WEST SUSSEX COUNTY COUNCIL CONSULTATION

TO:	Arun District Council FAO: Simon Davis
FROM:	WSCC - Highways Authority
DATE:	25 November 2021
LOCATION:	Land East of Drove Lane Yapton BN18 0EB
SUBJECT:	Y/156/21/DOC Approval of details reserved by condition imposed under Y/92/17/OUT relating to conditions 4-phasing for construction of dwellings & associated highways & public areas, 9-surface water drainage, 16-Construction Management Plan, 21-Travel Plan, 22-energy conversation, on site energy renewable devices & 25-electric vehicle charging strategy.
DATE OF SITE VISIT:	n/a
RECOMMENDATION:	More Information
S106 CONTRIBUTION TOTAL:	n/a

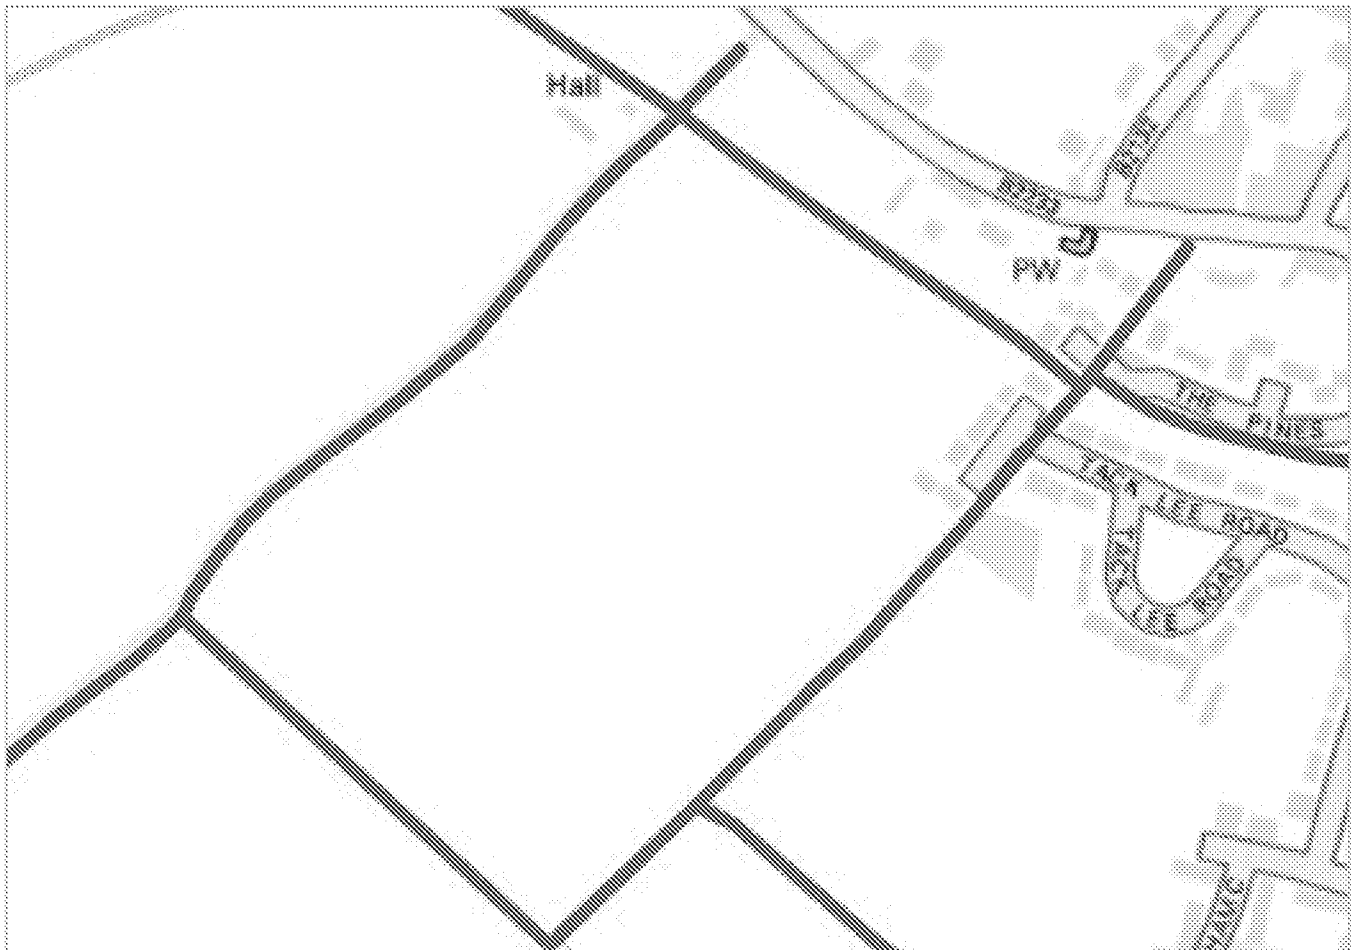
The applicant should note that they have made reference to liaising with Arun County Council in regards any closures of footpaths. They should contact West Sussex County Council in relation to these closures. Further information on the temporary closure of PROW is available here <https://www.westsussex.gov.uk/land-waste-and-housing/public-paths-and-the-countryside/public-rights-of-way/request-a-change-to-a-public-path/temporary-path-closures/>.
